Historic England

COMMENTS ON OTHER MATTERS REQUIRED

A1 Birtley to Coal House Improvement Scheme, Tyne & Wear

PINS Reference No: TR010031

APPENDIX A: PROPOSED ACCOMPANIED SITE INSPECTION ROUTE

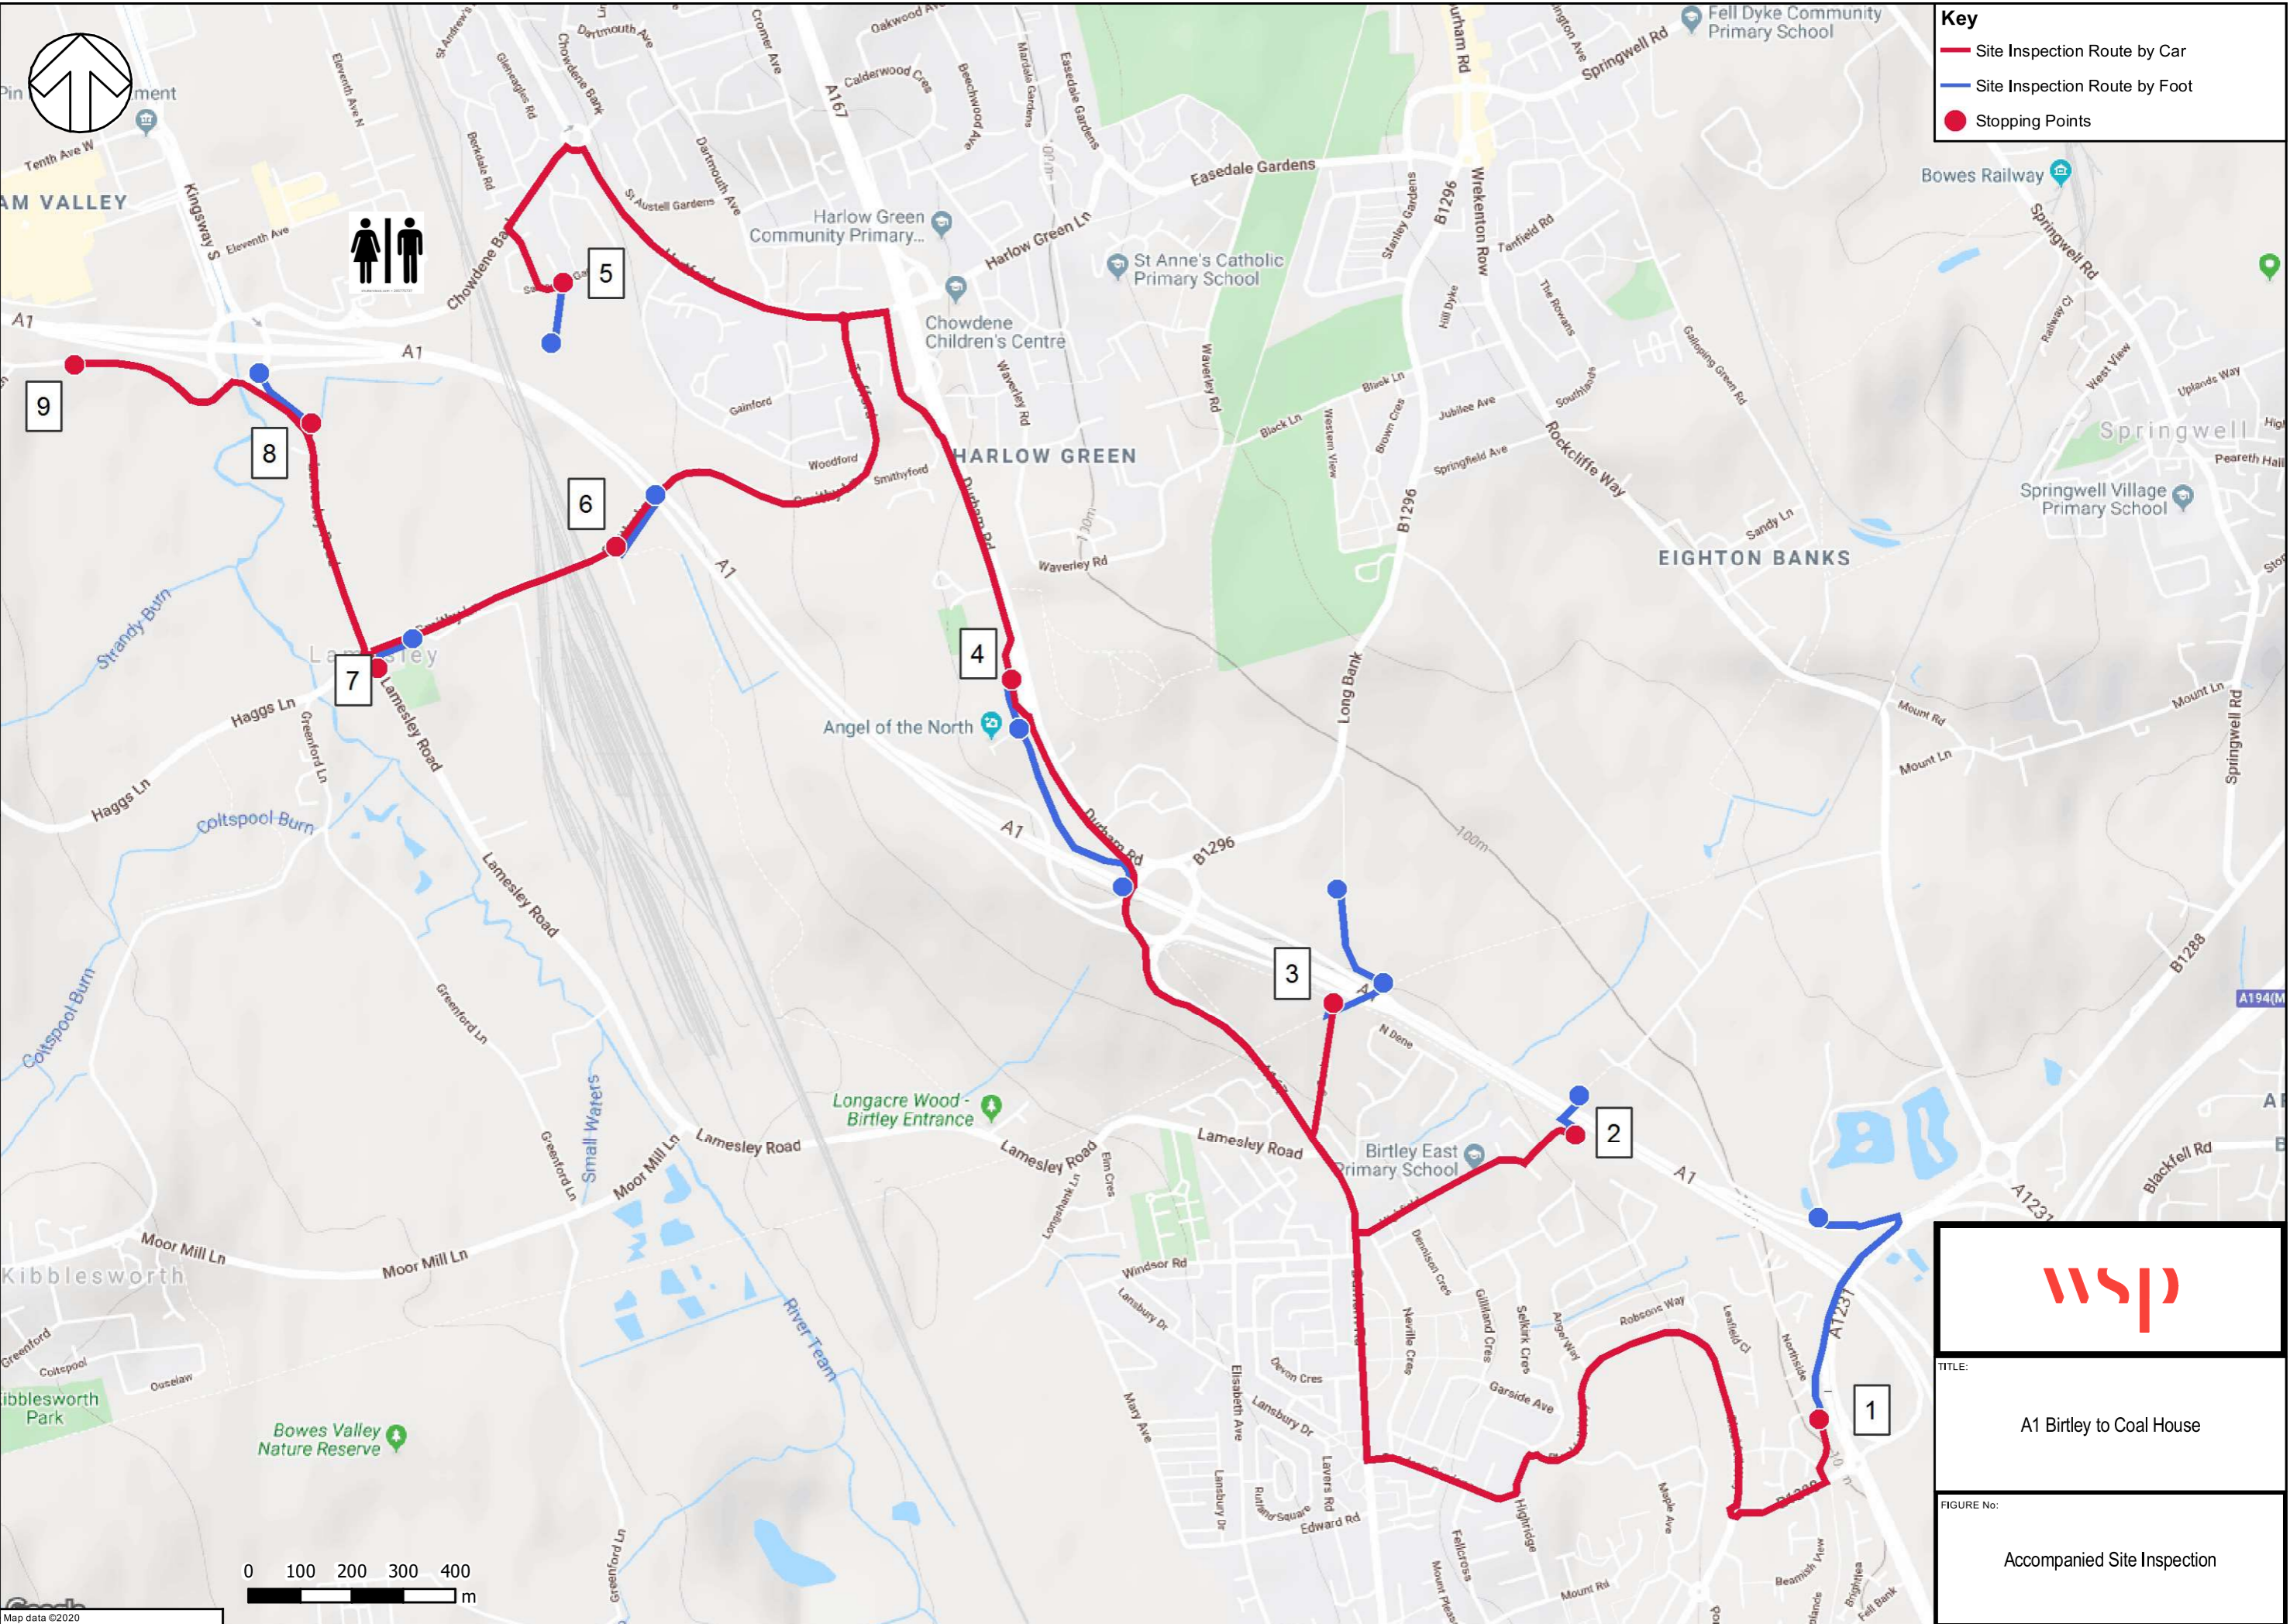
5.1 Historic England note that Highways England has submitted (REP1-004) a draft itinerary for the Accompanied Site Visit. We further note that Stop 3 relates to the Longbank Bridleway Underpass. We would like to suggest an amendment to Stop 3 on the Accompanied Site Inspection schedule due to its location in relation to the Bowes Railway Scheduled Monument.

5.2 We suggest that the opportunity therefore is taken at Stop 3 to view the Scheduled Monument and the proposed works on the North side of A1. Changes are proposed not only to the tunnel but also to the existing footpath arrangement as it comes down onto the monument (the bridleway) which the Examining Authority may wish to note and take into consideration.
